From: drew Jones <[REDACTED]>
Sent: 18 October 2019 17:48
To: Simon Davis <[REDACTED]>
Subject: Re: Y/53/19/NMA - North Barn, Hoe Lane

Rev A Oct 19  
setting out of north windows  
amended

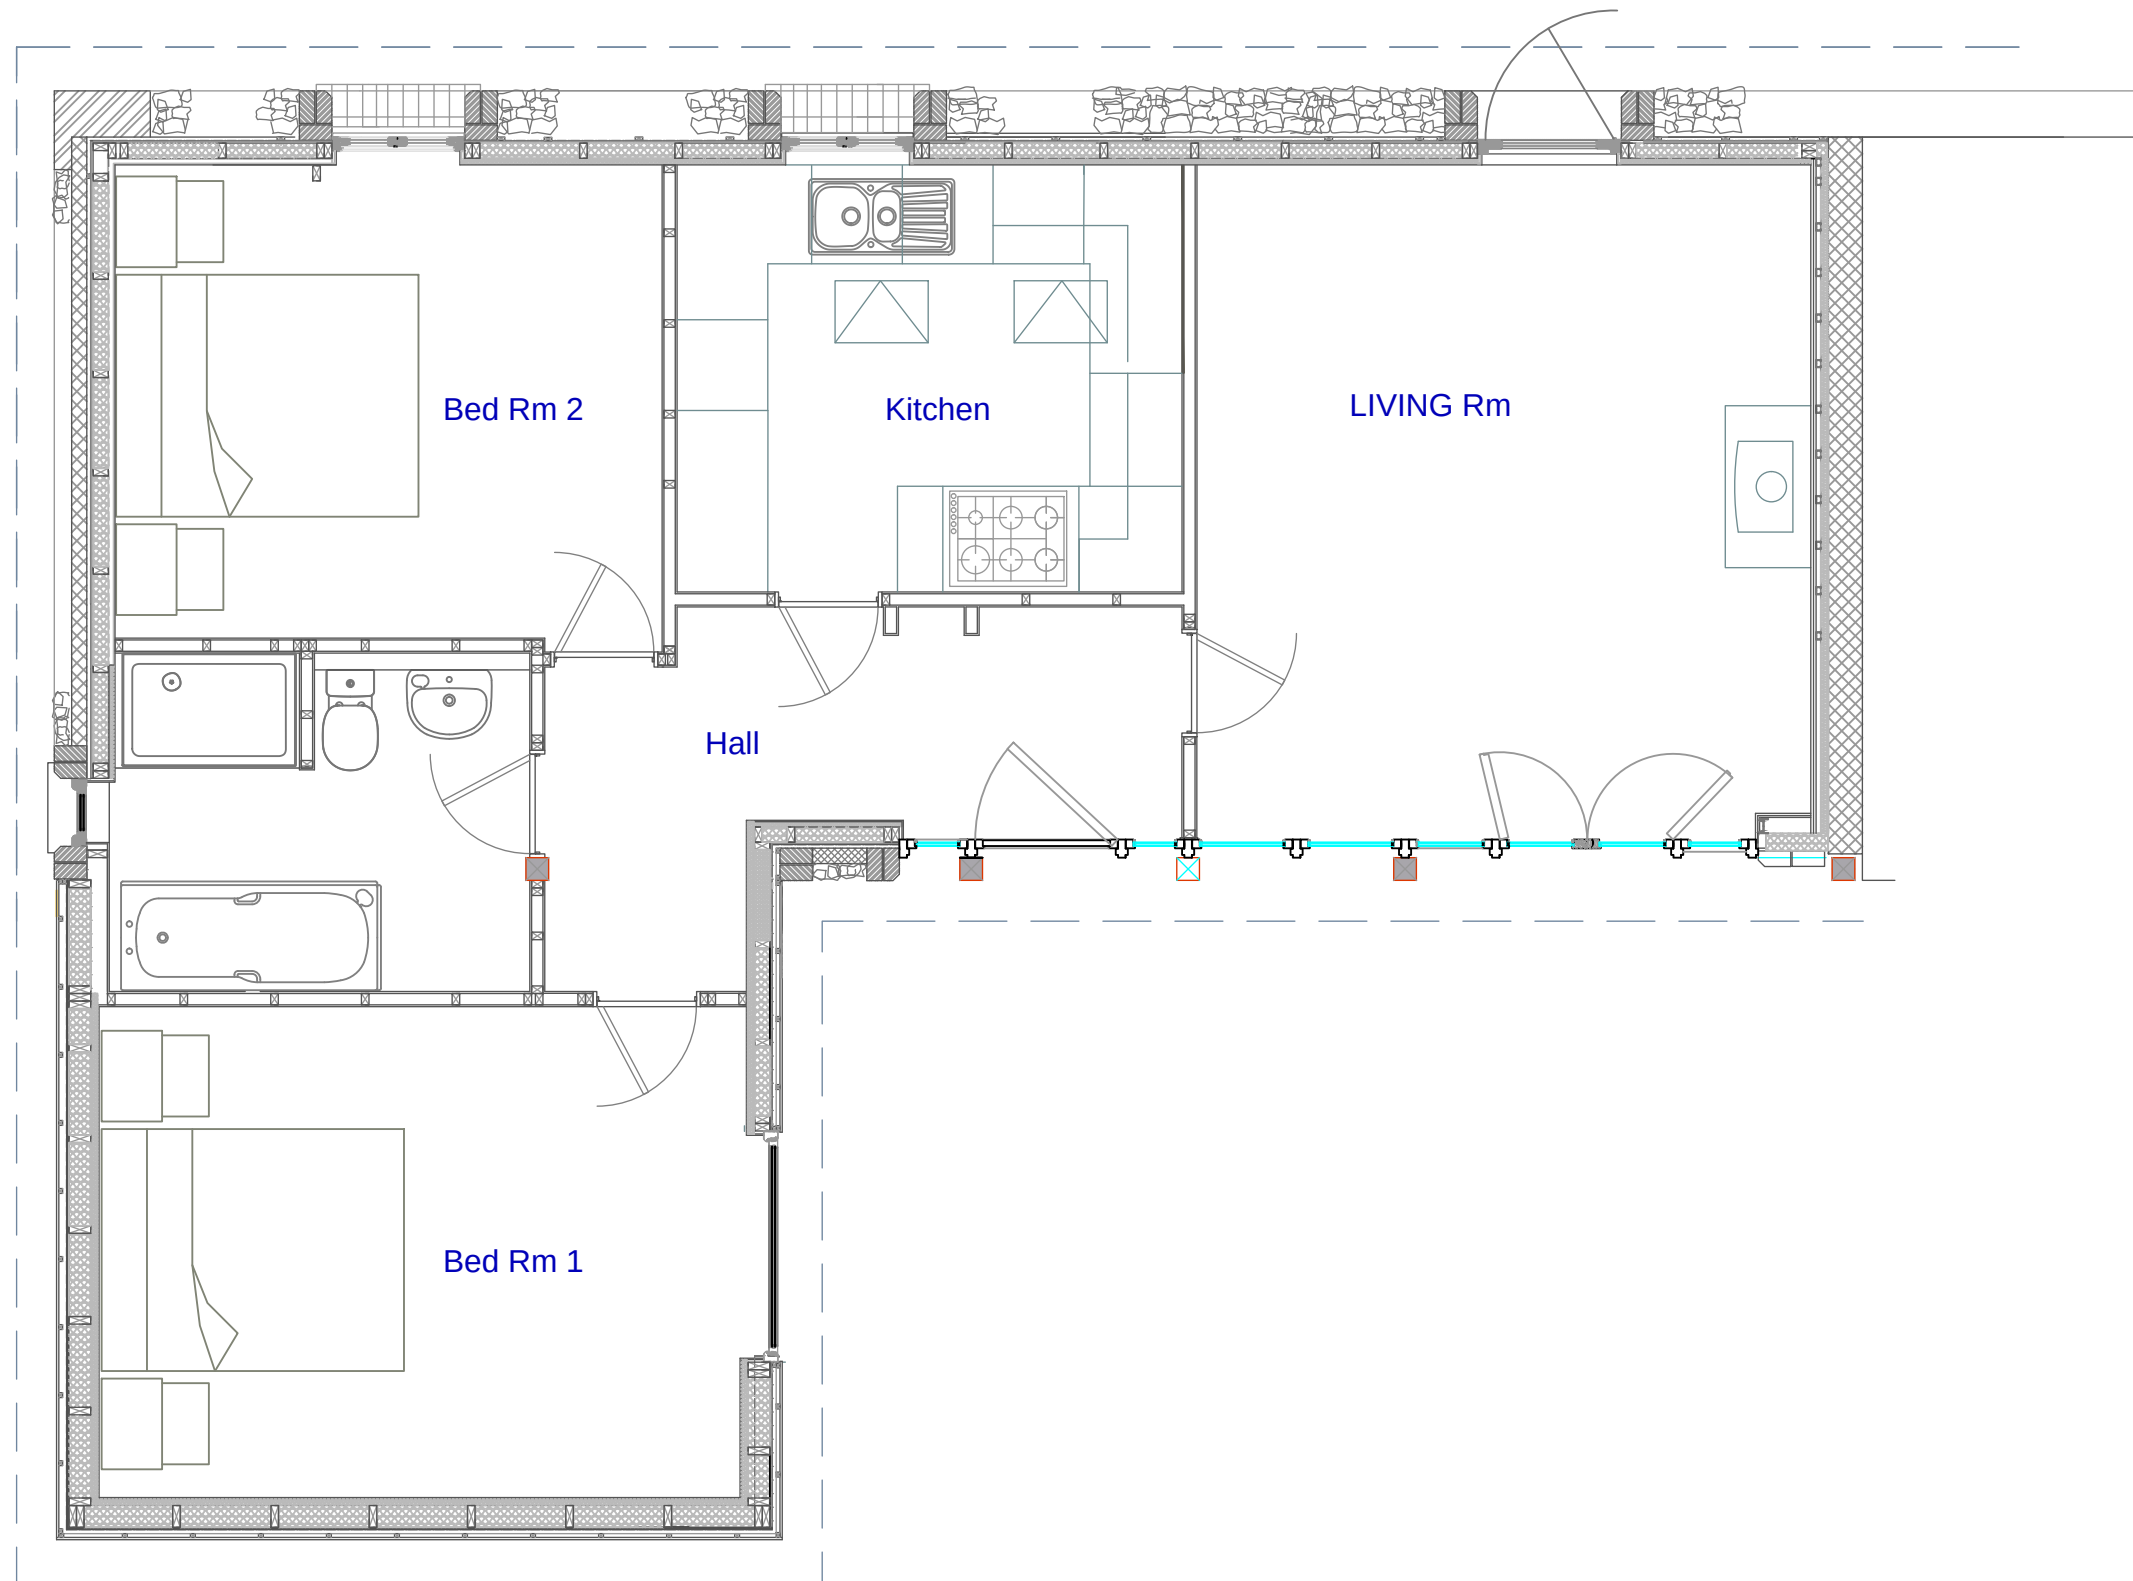
I have today discussed this matter with our Conservation Officer. He does not object to the use of timber boarding or the setting of the windows/doors behind the existing timber posts. However, he does have some concerns with the changes to the 'french door' windows on the north elevation. Although he prefers that there is now no longer a gap between the top of the door and the eaves, he does not like the fact that you can tell from looking at the windows where the opening is. He prefers the uniformity of the windows/doors approved on the original scheme. If you are able to change this then we can accept the scheme as a NMA. Please feel free to call to discuss.

apologies for the delay.I attach amended drawings of the north elevation (13-1 Rev A) and the GA (17-1 Rev A)
